| PLAN SHOWING THE PRO. ADDITIONS & EXG. BUILDING TO BE REGULARISATION IN S.N. 42/181A/AVADI MUNICIPALITY. |

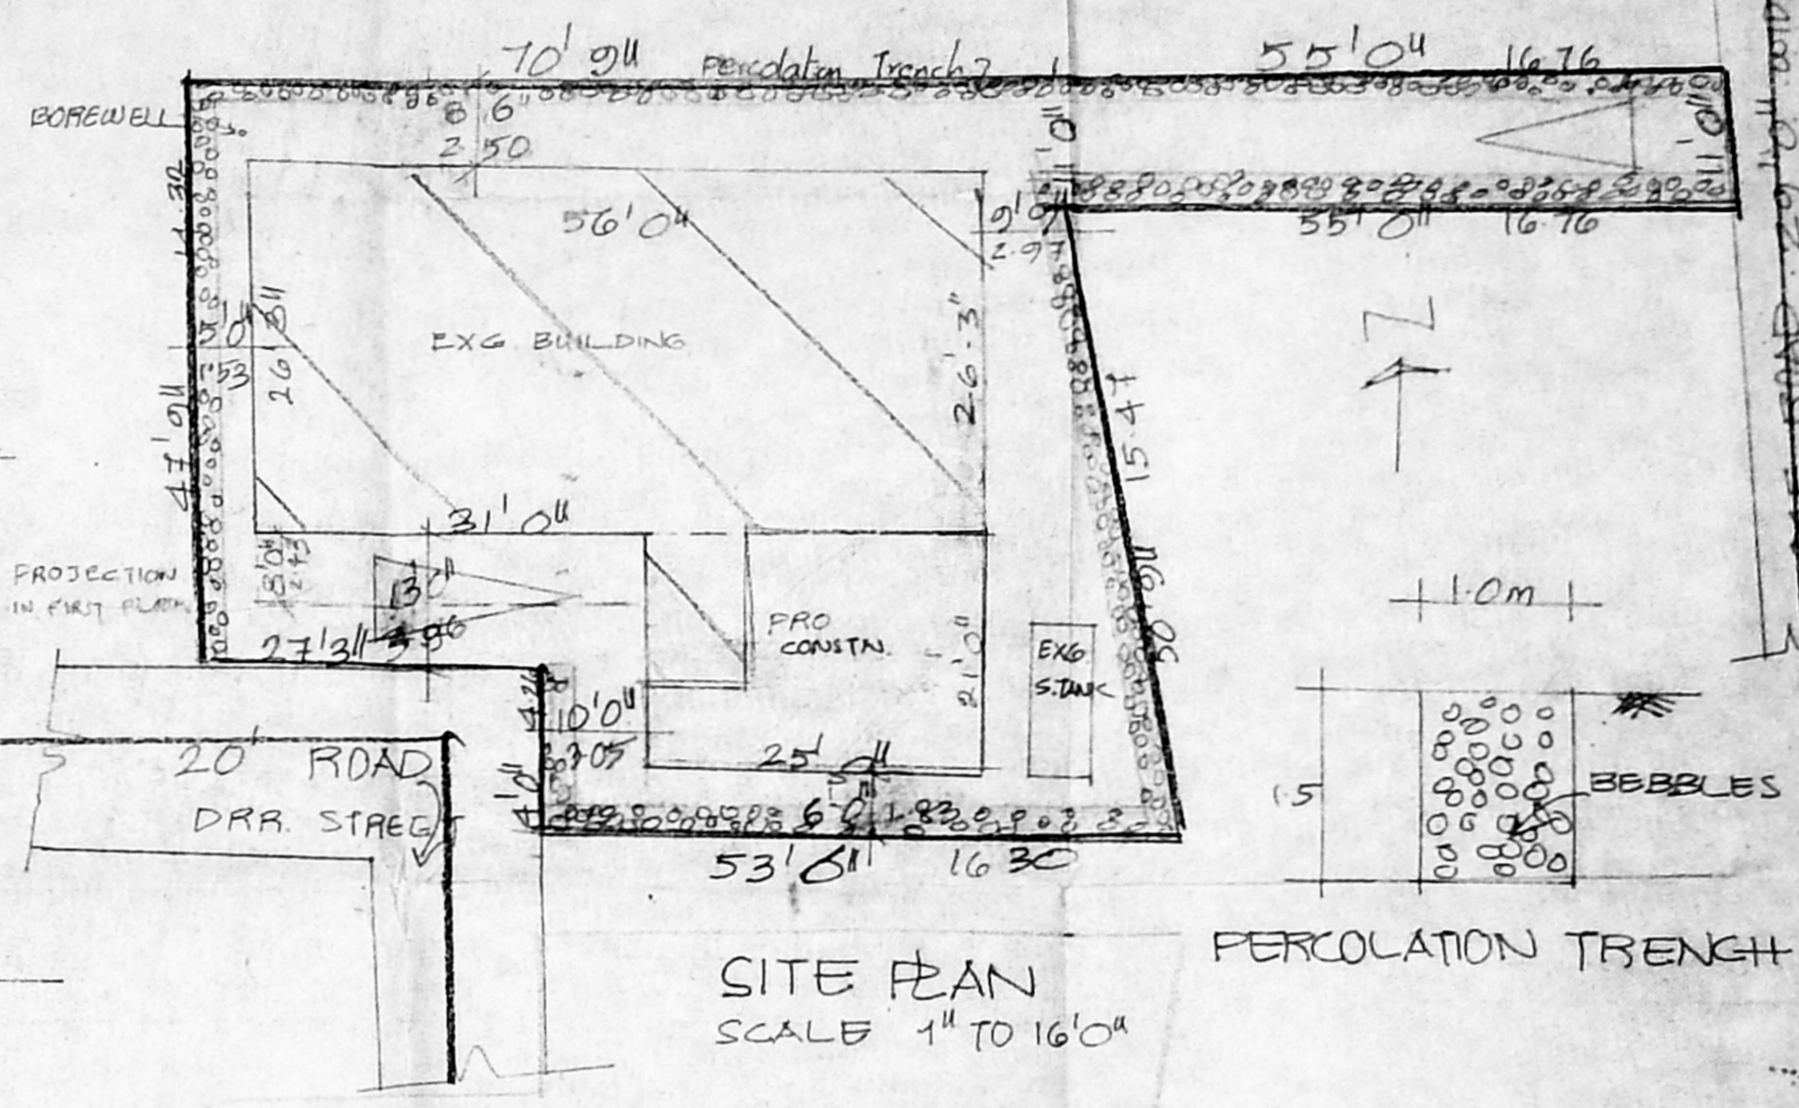
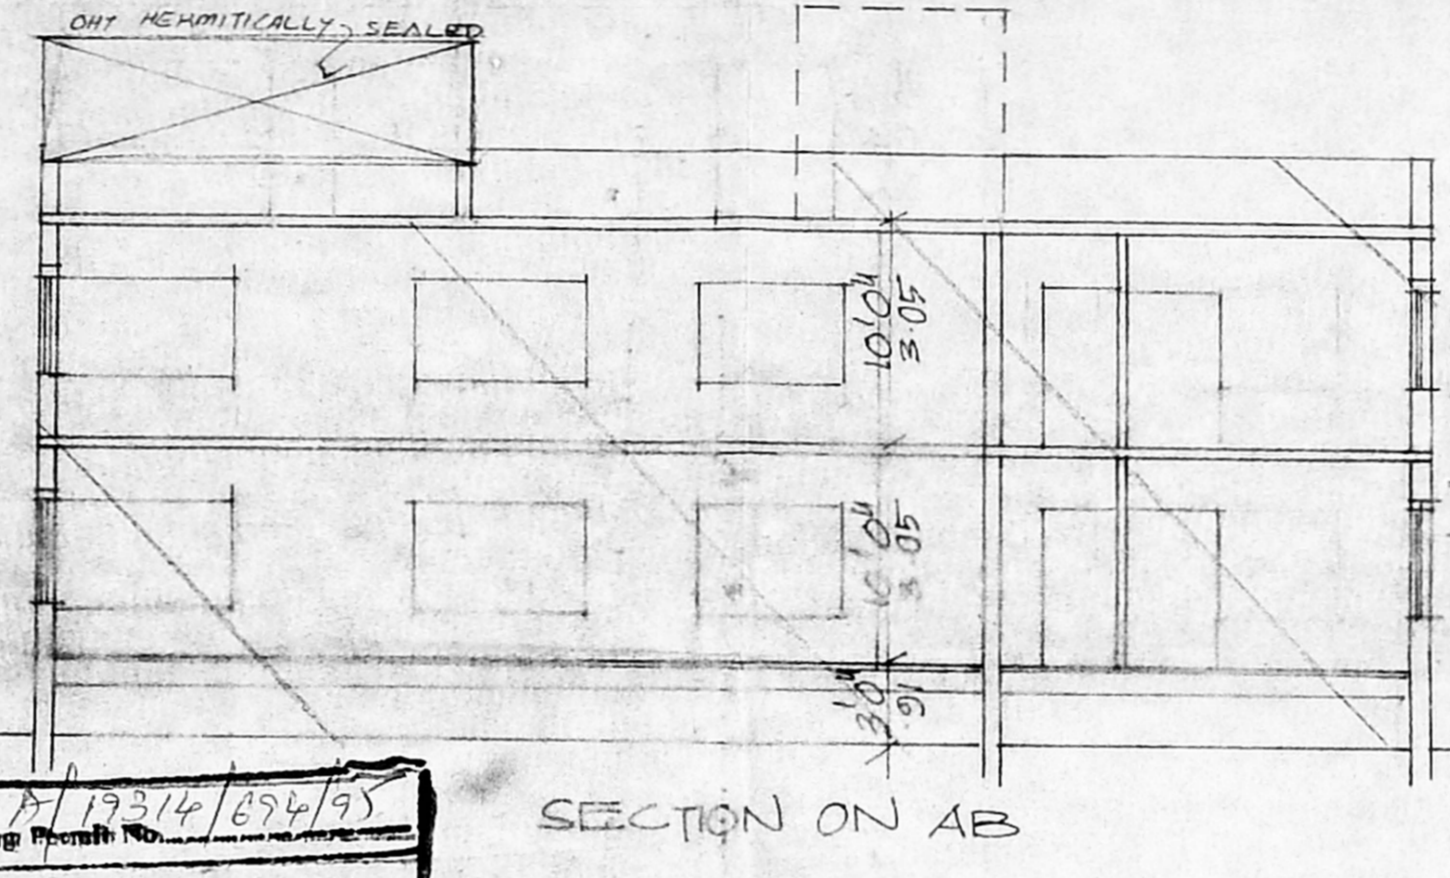
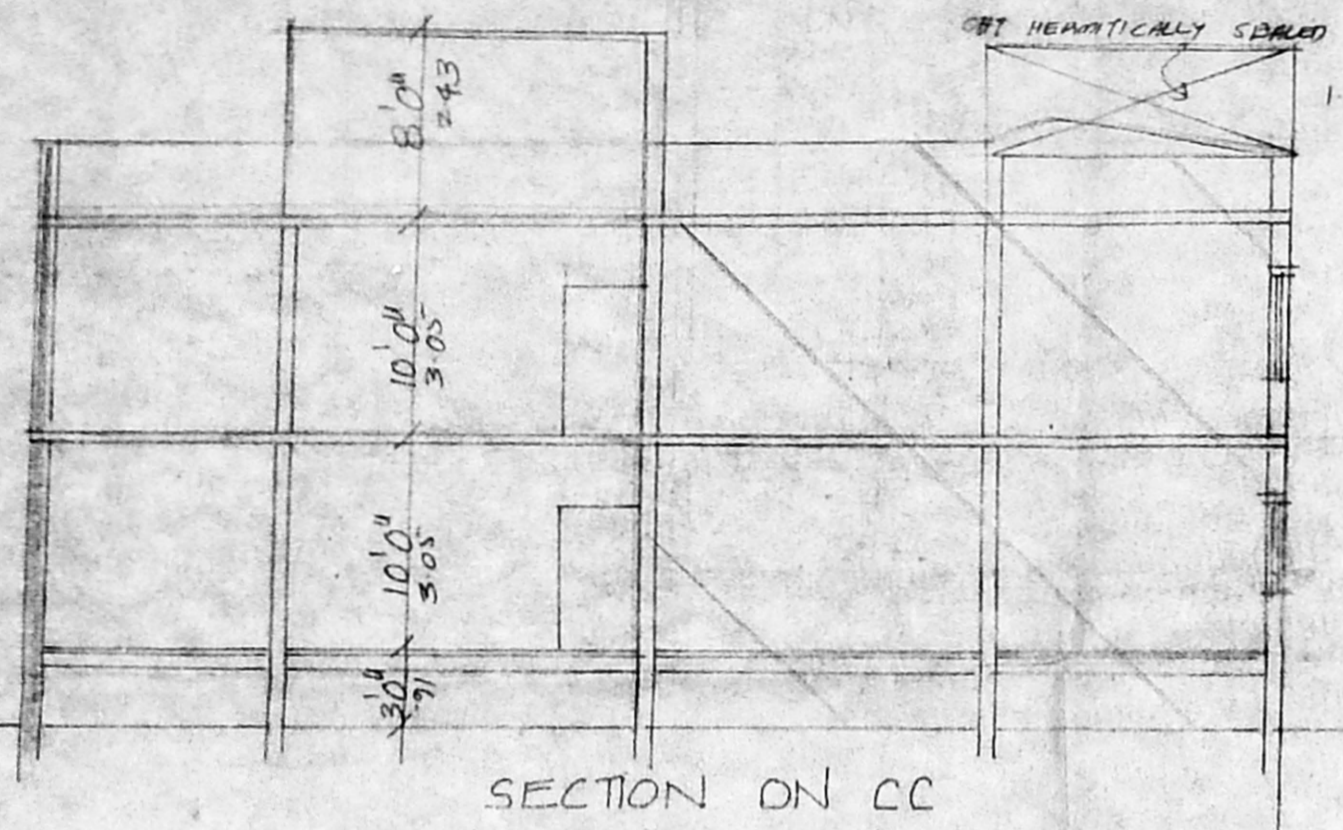
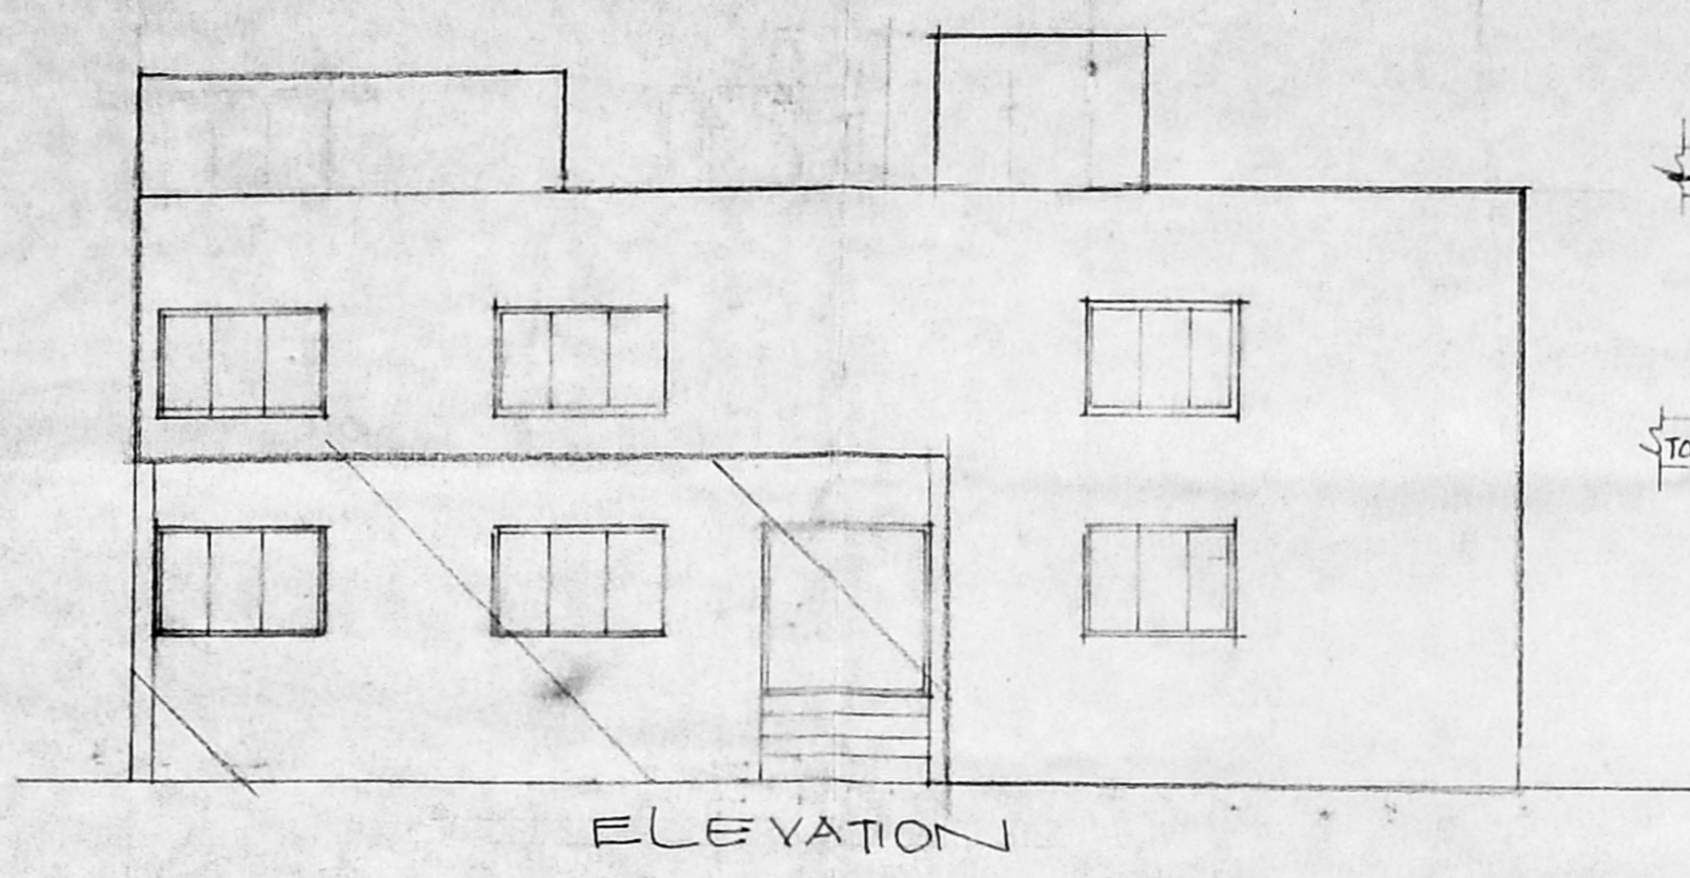
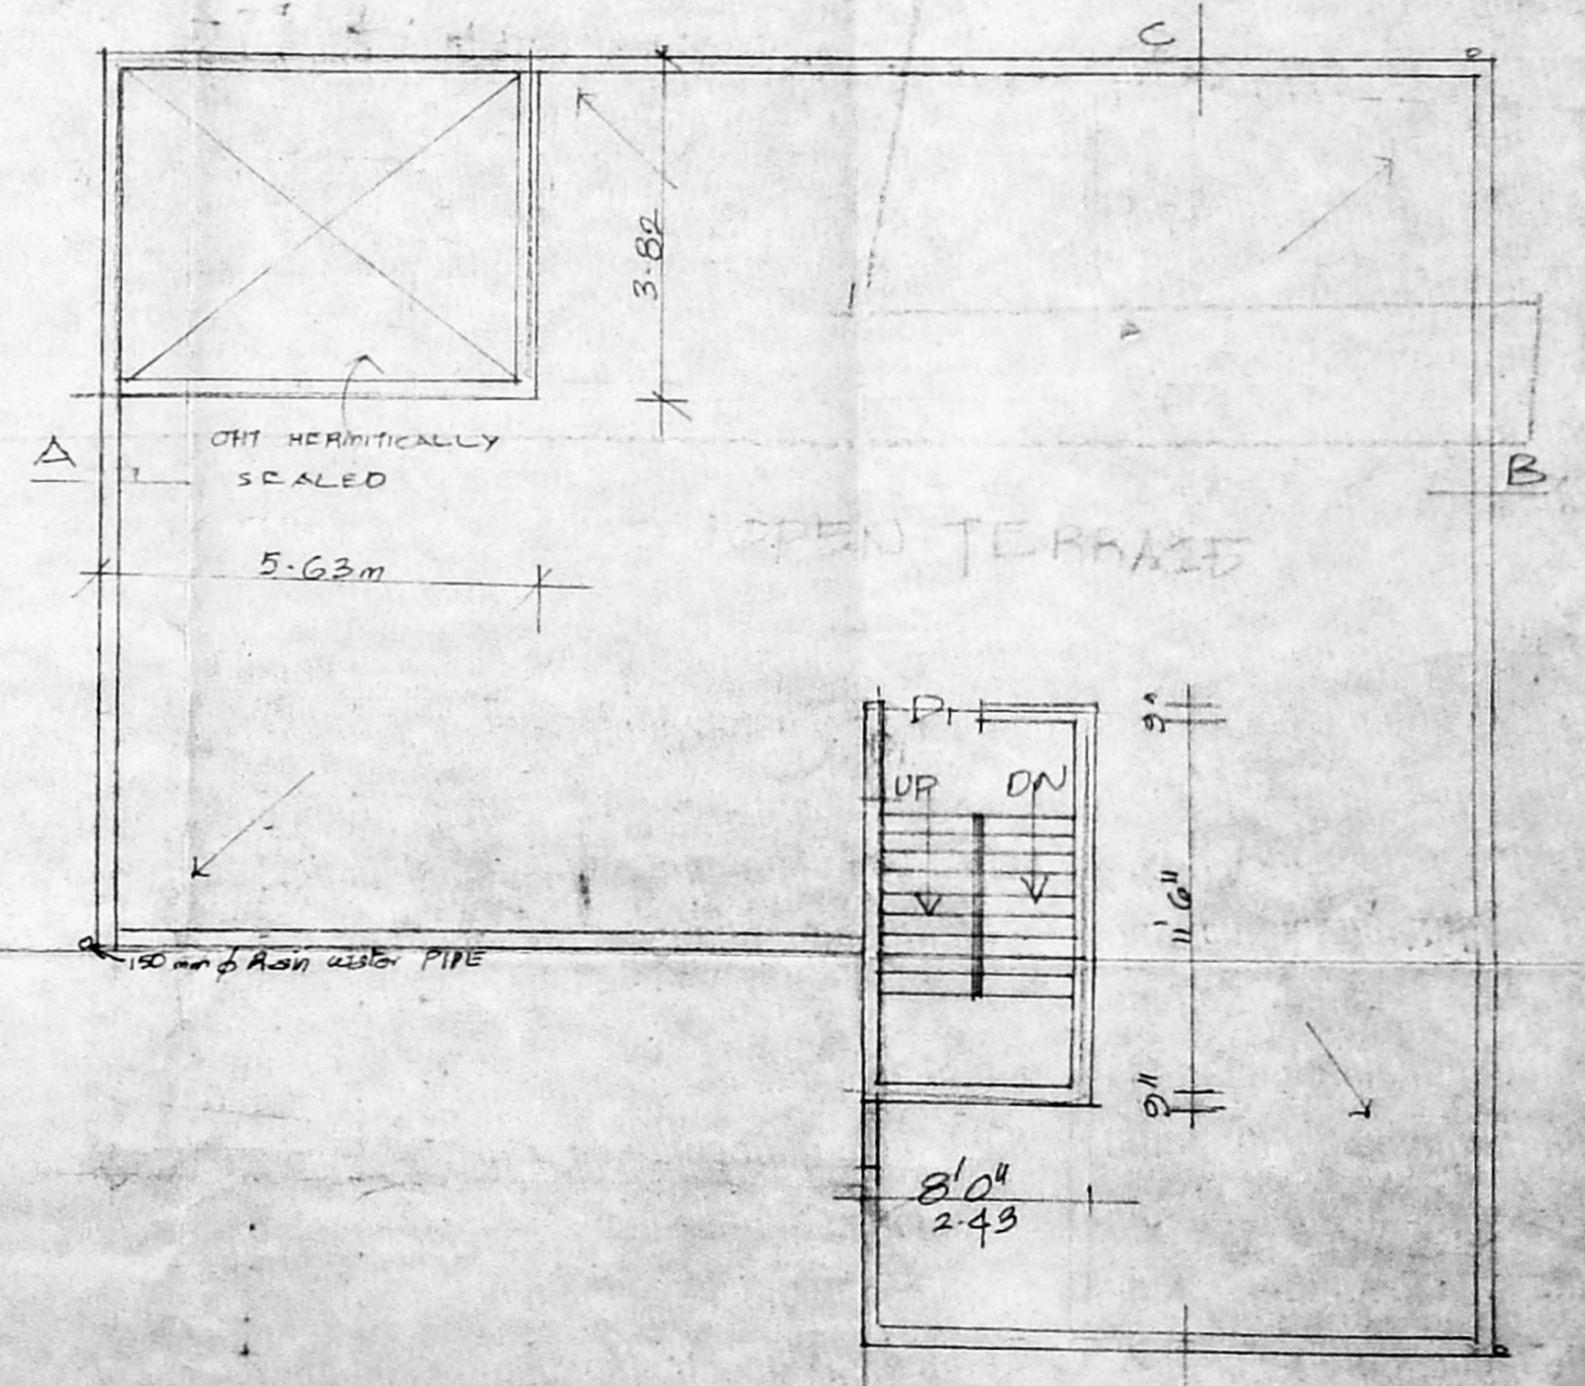
- a) Rain water conservation regulations
- b) Rain water conservation regulations notified by MMDA, should be adhered to strictly.
- c) Five copies of revised plan ~~at~~ mentioning as ~~Dear Sir~~, regularisation & proposed addition and ~~Dear Sir~~ in a file of a plan.
